March 26, 2012

RE: Storm Cloud Subdivision, Units 4 & 5--Drainage Report Submittal 2/10/12 (H9/D022)

**Re: Storm Cloud Subdivision, Units 4 & 5
Drainage Report
Engineer's Stamp Date 2/10/2012 (H9/D022)**

GRADING AND DRAINAGE PLAN

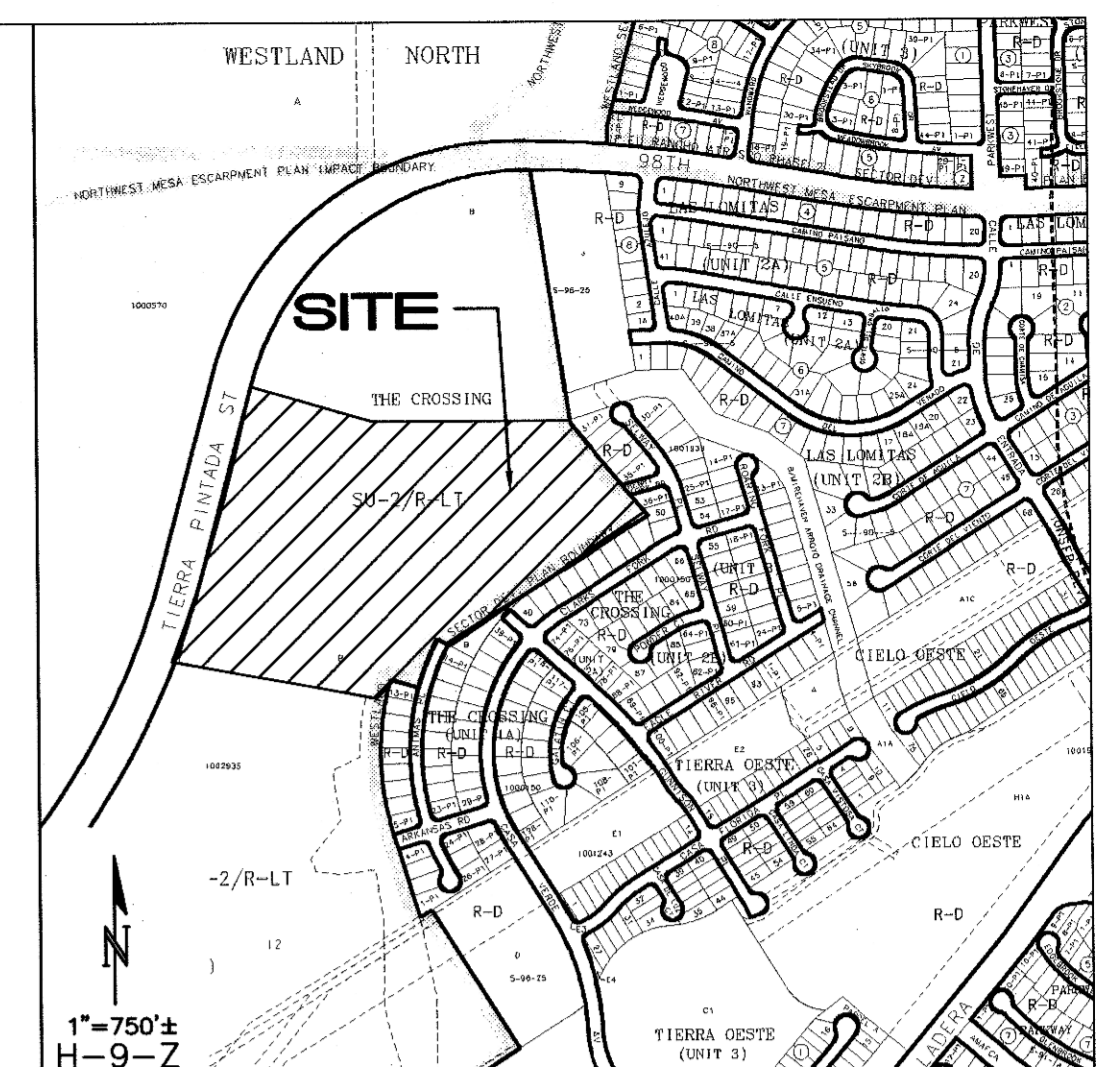
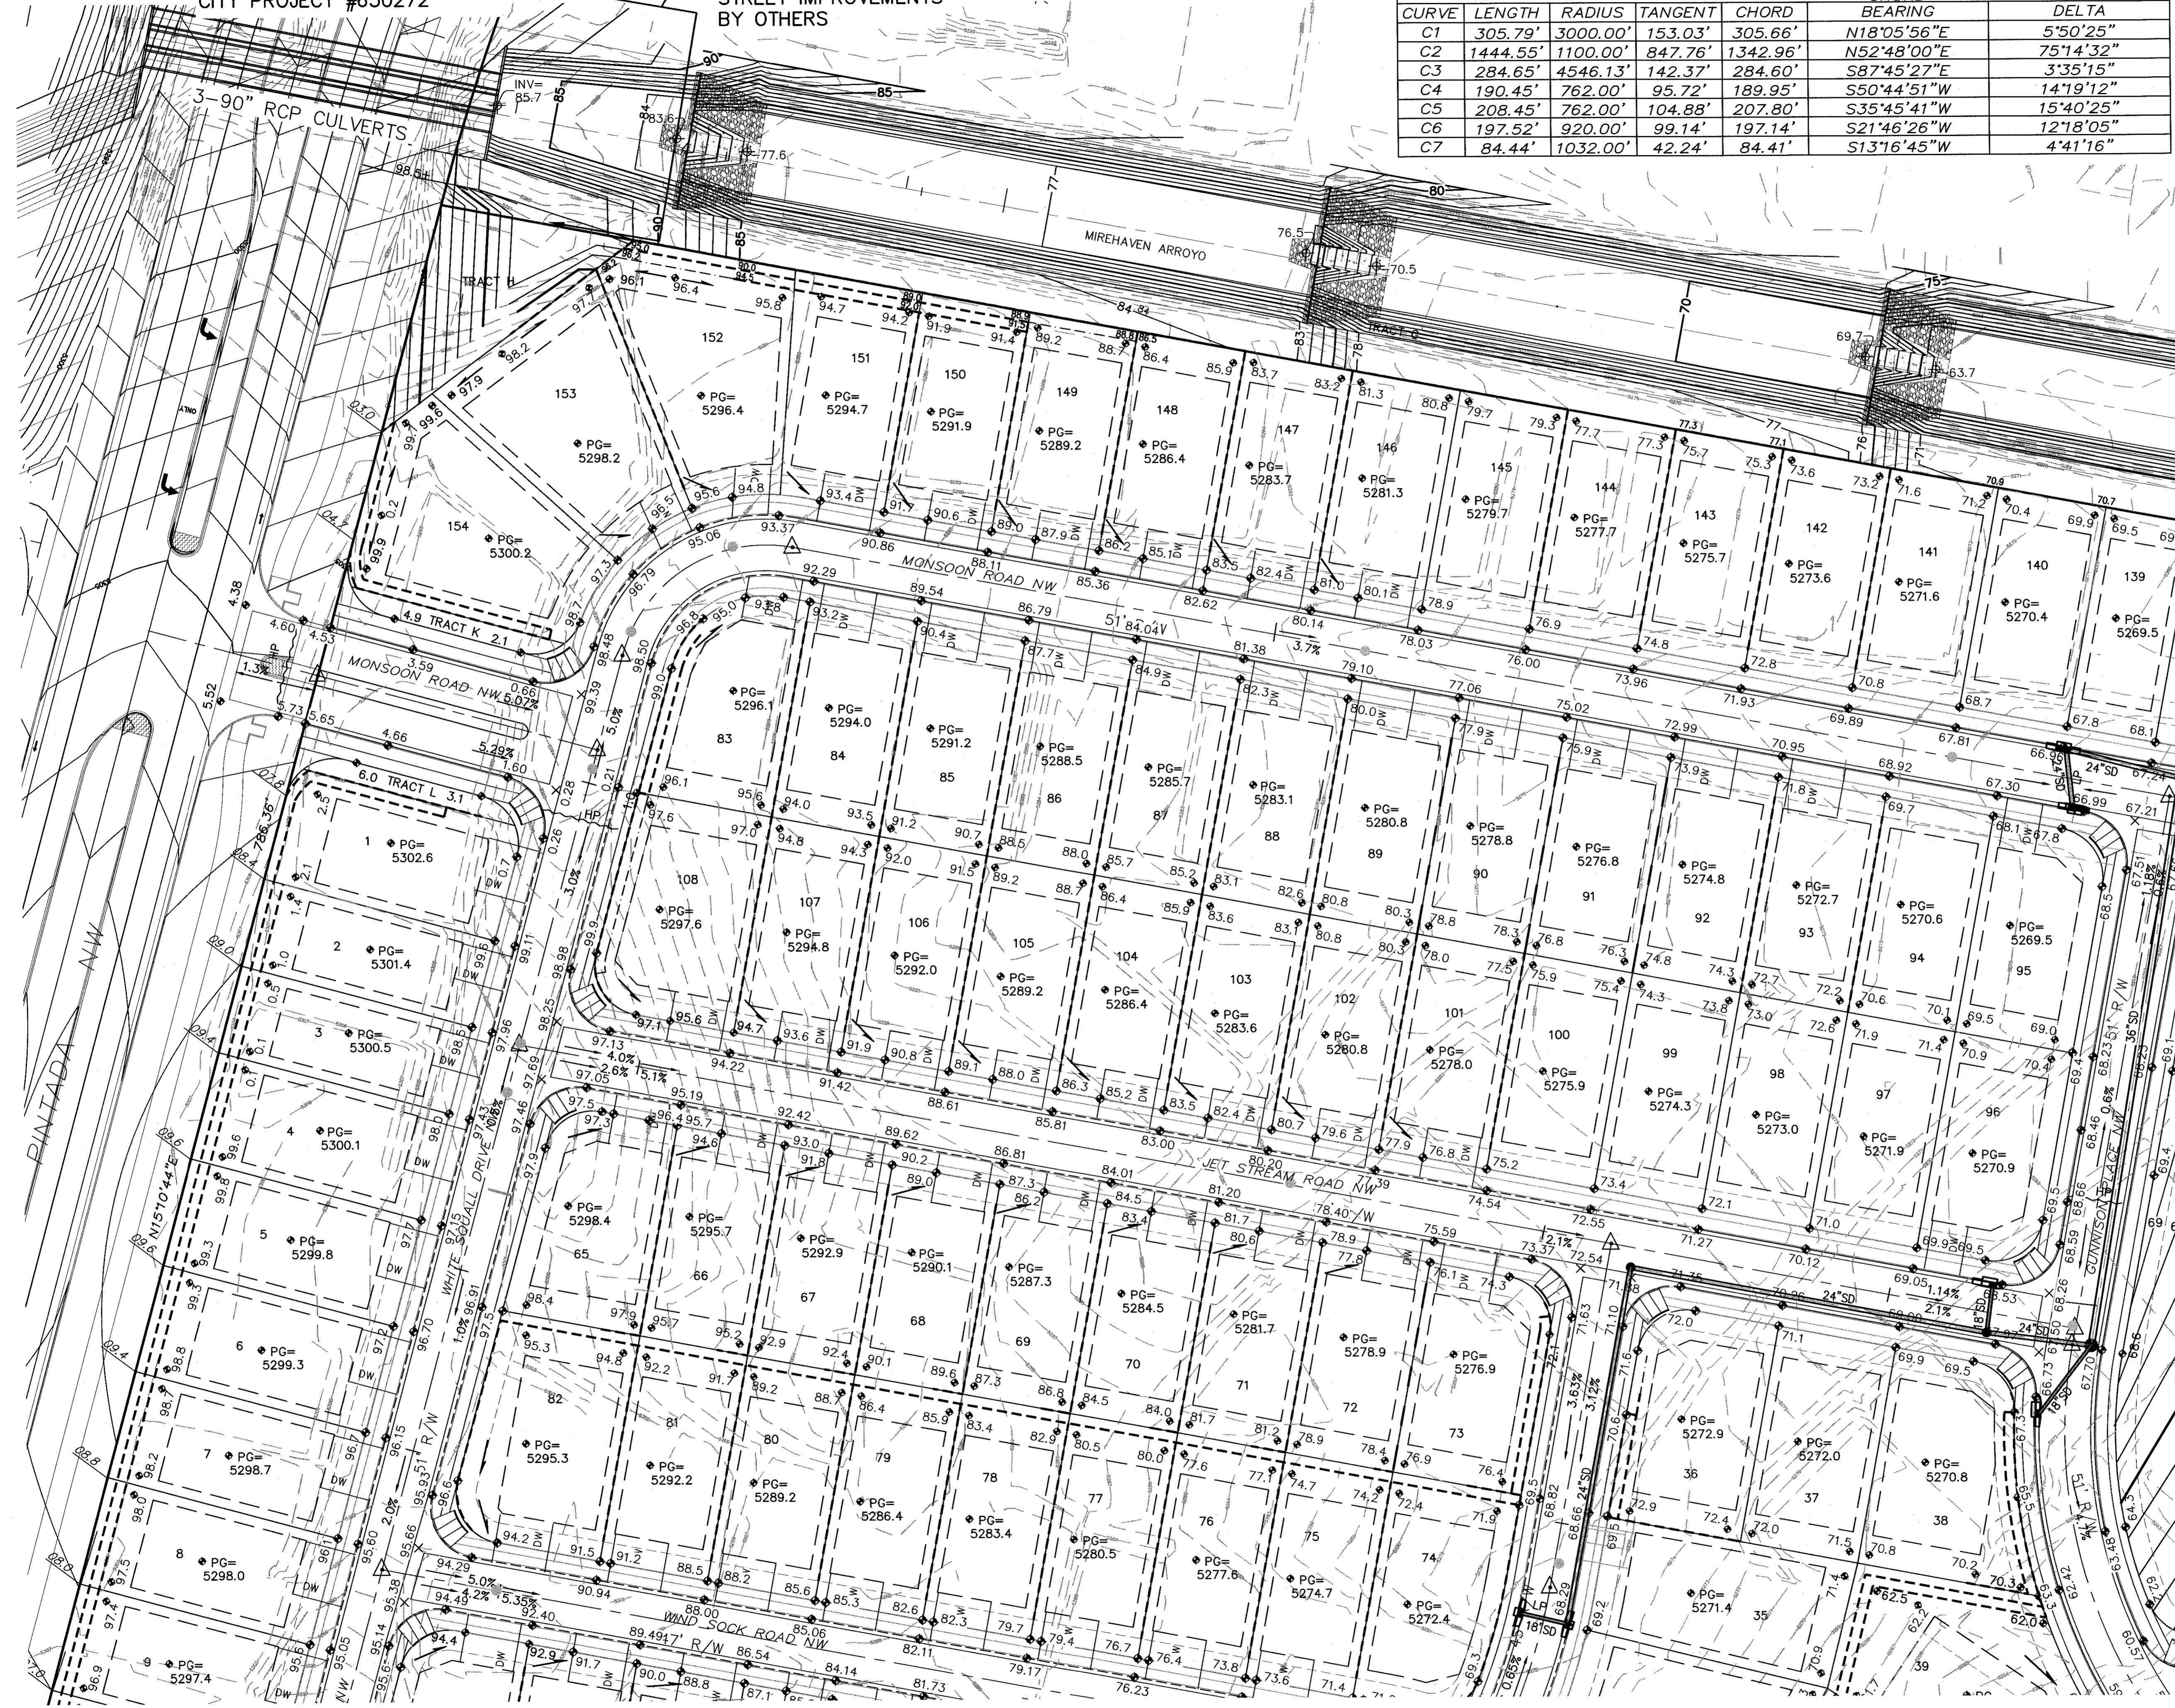
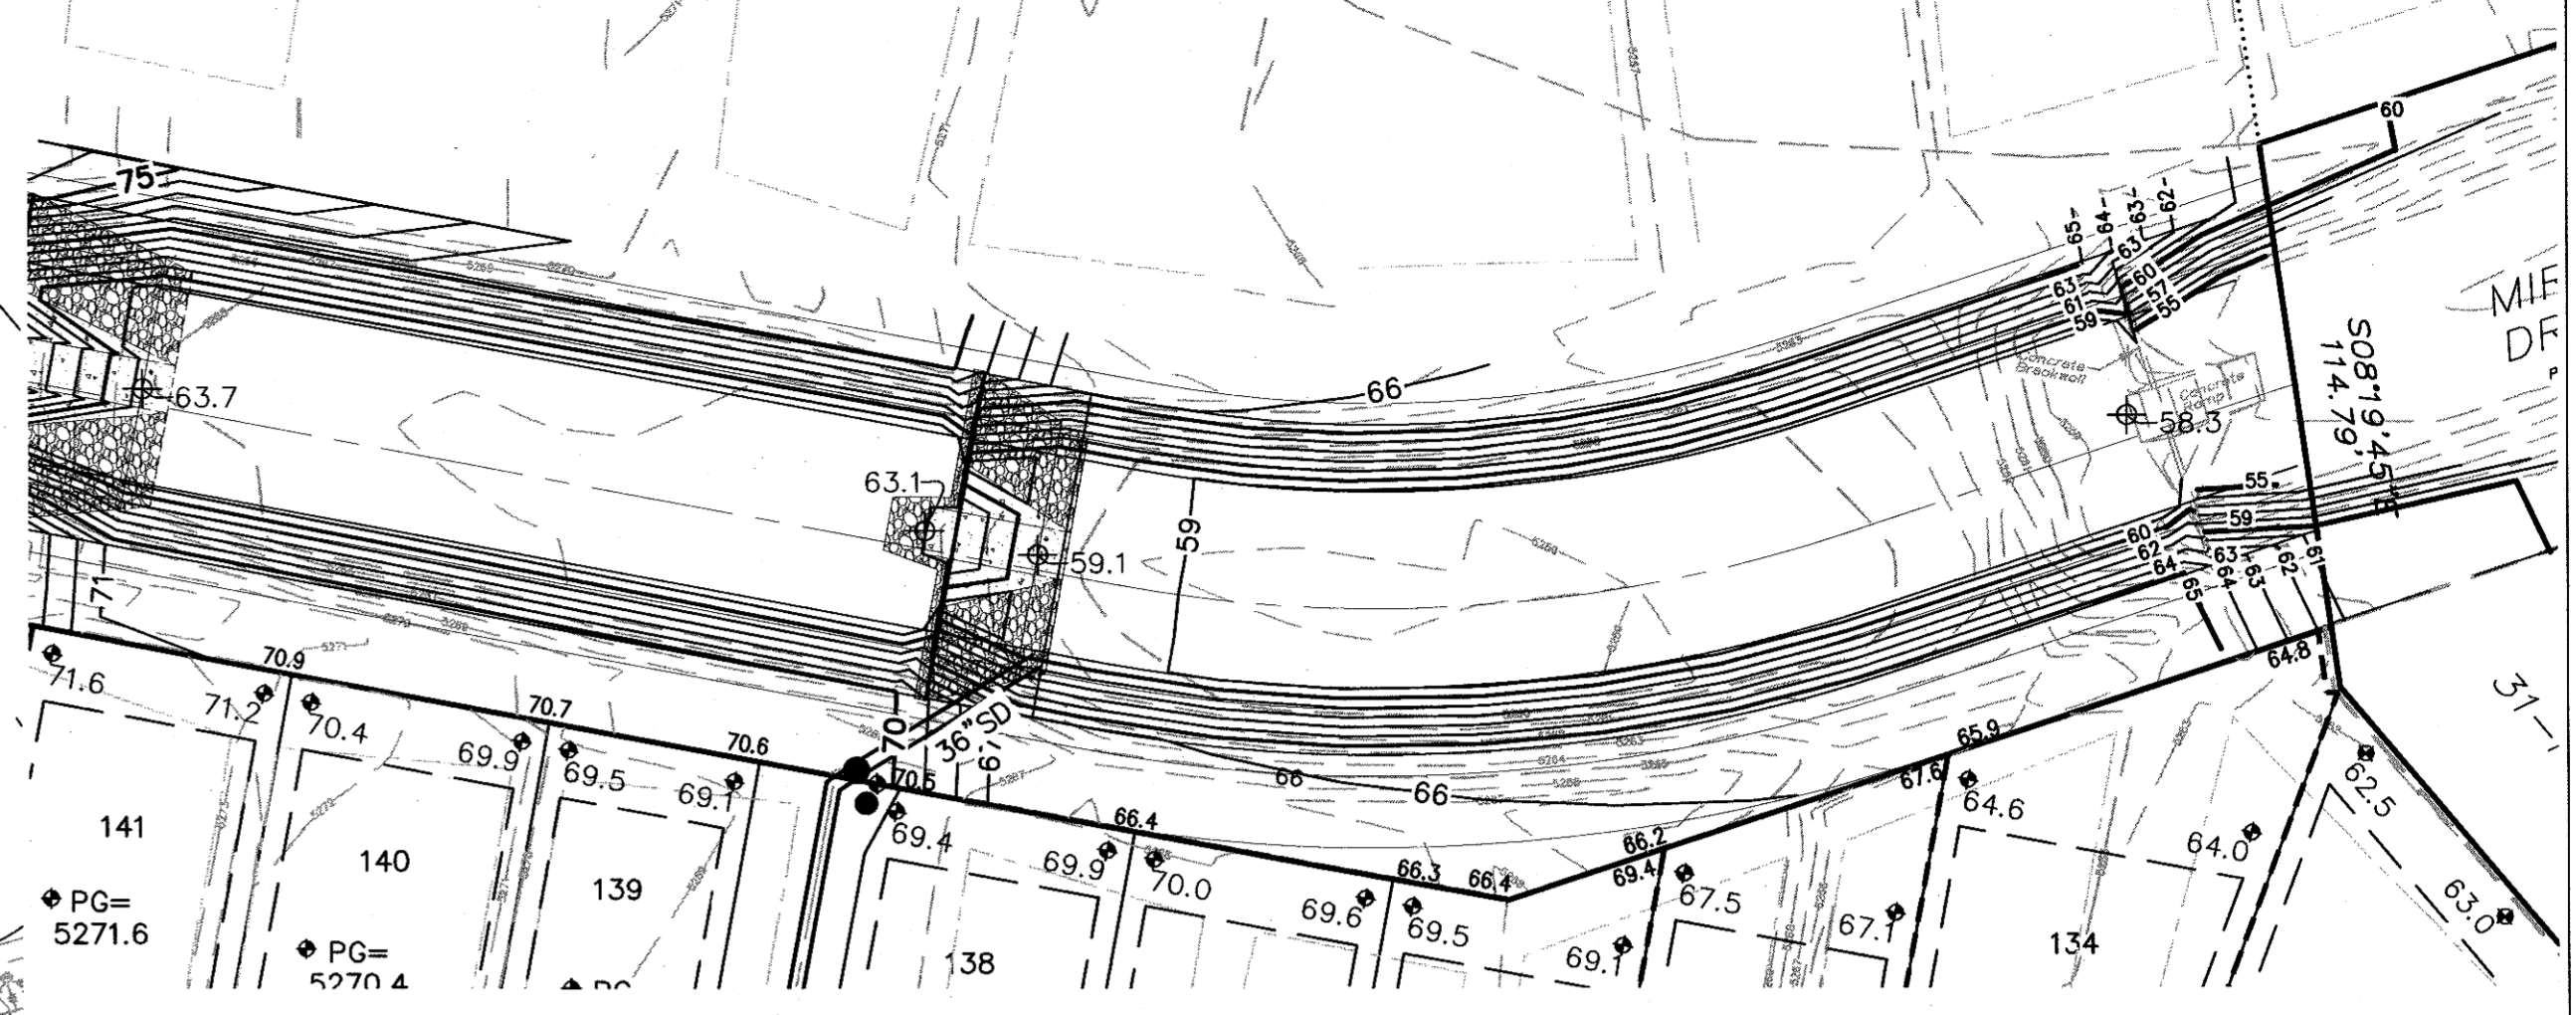
1. *Show proposed Tierra Pintada Blvd. and grades on the plans.*
Added per Bohannon Huston plans.
2. *Show proposed Tierra Pintada Blvd. 3-90" RCPs and grades on the plans.*
Added per Bohannon Huston plans.

4. *Remove Mirehaven stationing from the grading plan and include them on a separate sheet with updated channel analysis.*
Stationing was removed from grading plans. Plan & profile exhibits of the Mirehaven Arroyo are included in the Revised/Supplemental Calculations.

10. *Fix the text overlaps on the grading plans.*
Fixed.

13. *Proposed legends for curb and gutters do not match the actual layout on the grading plans.*
Fixed.

GRADING AND DRAINAGE PLAN

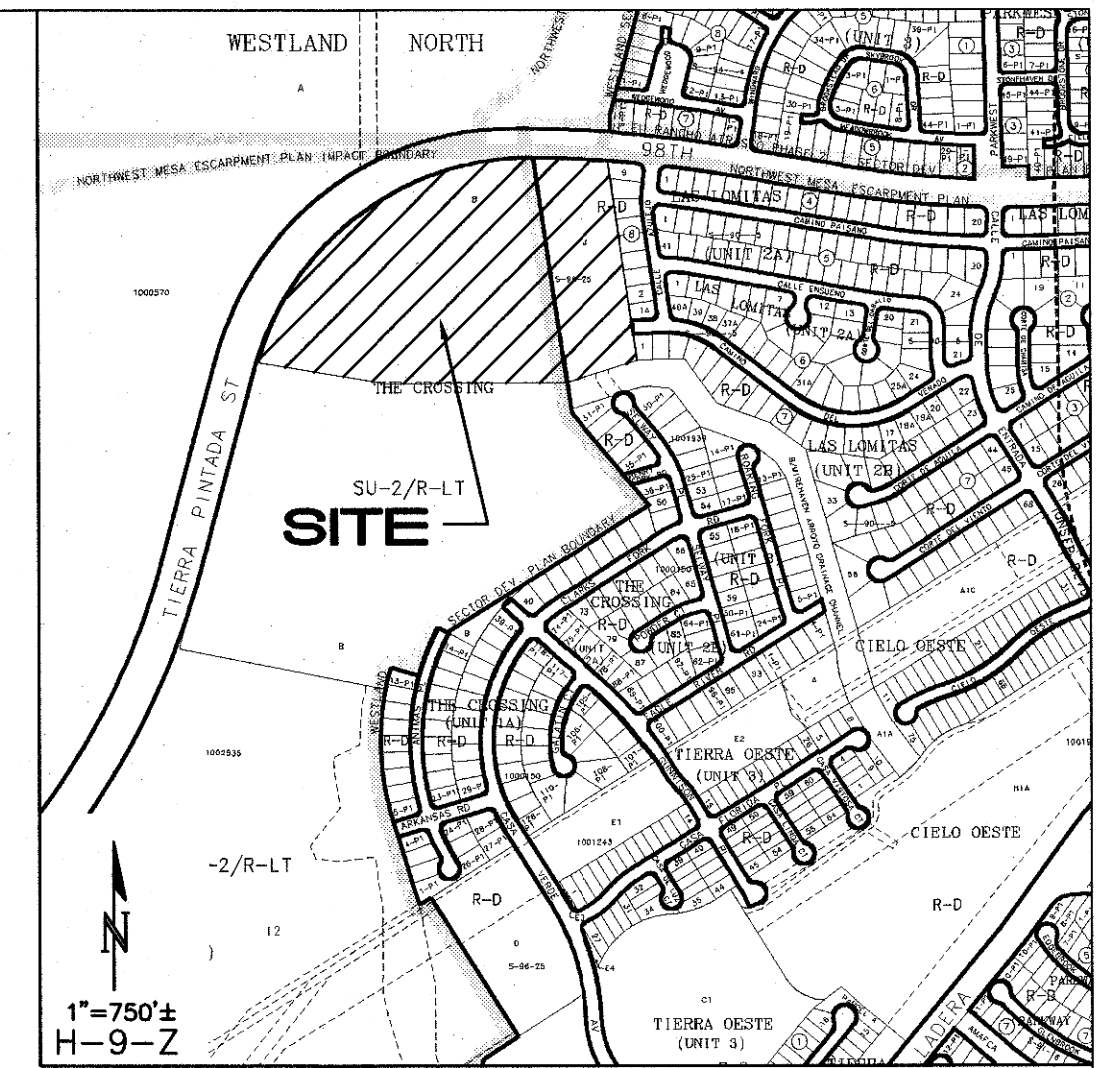
7. *Inlets 5, 6 & 7 under Unit 5, are designed to be in swamp condition. Please make sure that all three inlets are built with the same top of grate elevation and 0.67' head is provided. The runoff should not overflow to the east. The high point in the street is at 58.67' and grate elevation is at 58.04'.*
The high point elevation is at 58.71' per profile exhibit of Camino del Venado included in Revised/Supplemental Calculations. Inlets 5 & 6, both double-grate inlets, will capture 41.3 cfs at a head of 0.67', and inlet 7 which has a higher top of grate elevation, will capture the remaining 2.6 cfs. Flows will not overflow to the east.
